Our Ref: P/86/15/PL

1 No. 2 bedroom semi-detached bungalow

11 Abbotsbury Pagham

Thank you for your internet representation made on 22nd September 2015 which has been recorded as '**an objection**' with the comments as follows:

Proposed Floor Plan & Site Plan

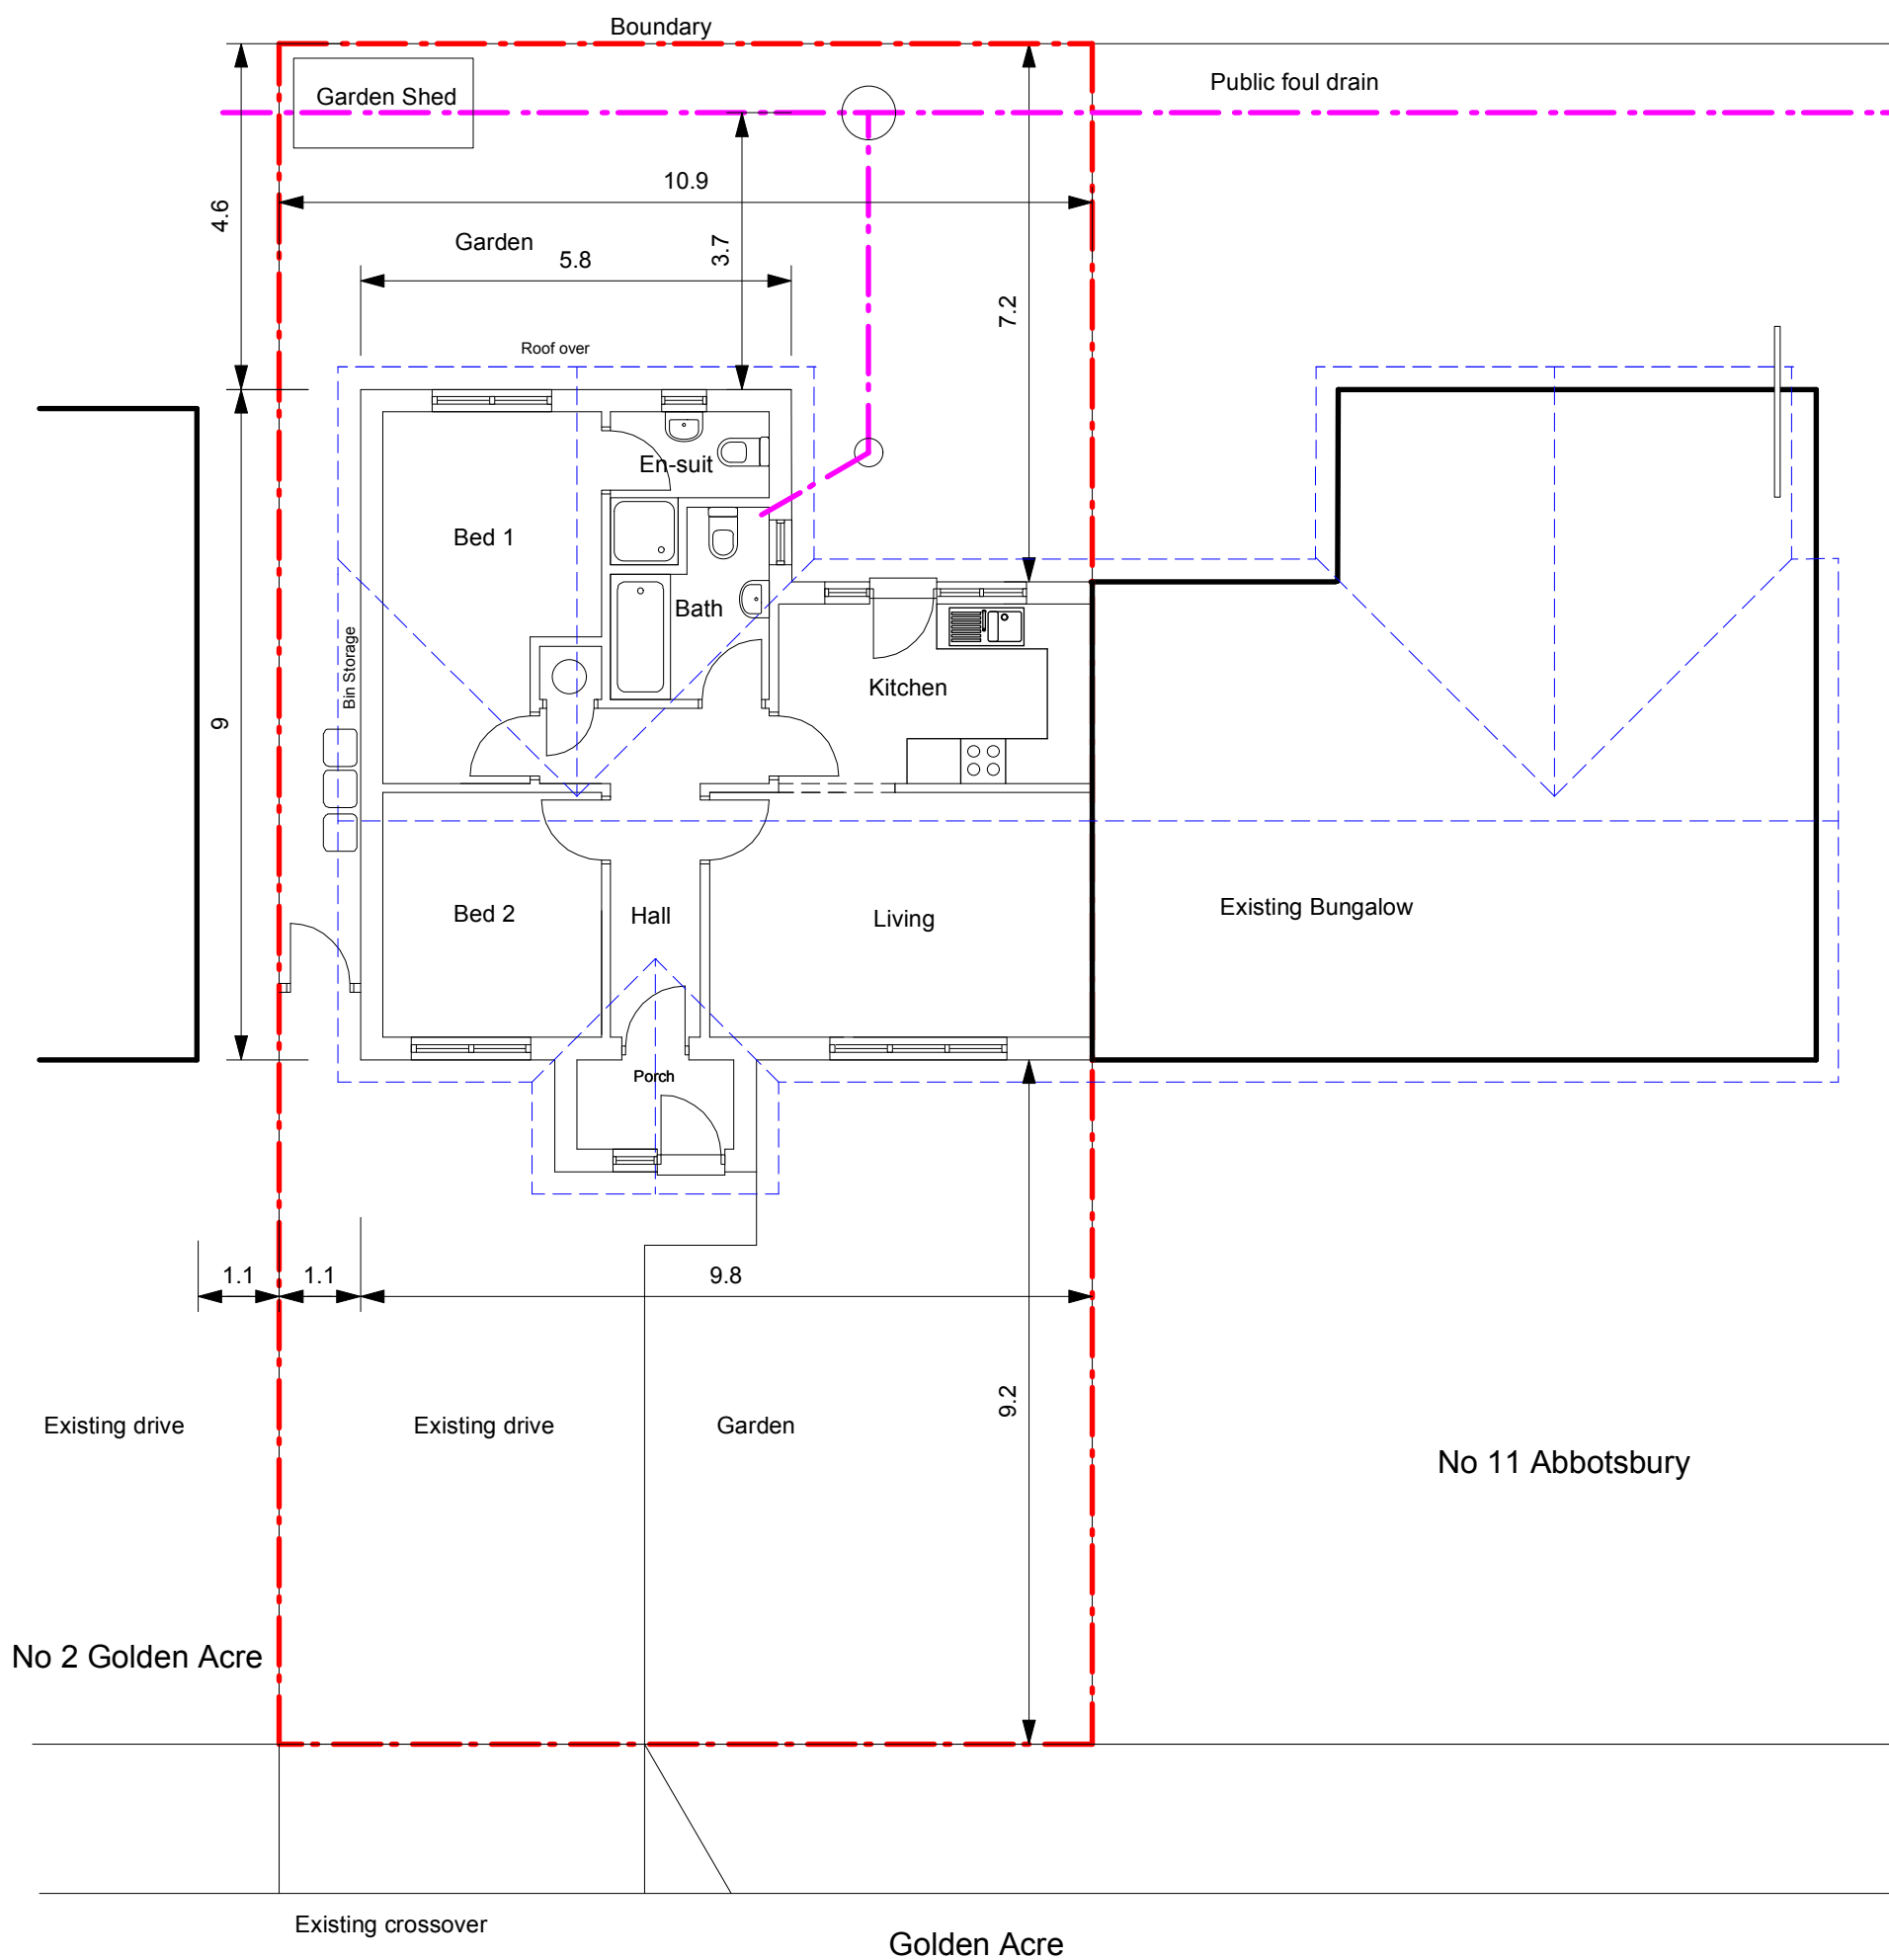
The plans include a new driveway for number 11 Abbotsbury, but there is no mention of the requirement of a dropped curb on this site, although this is drawn in the plans.
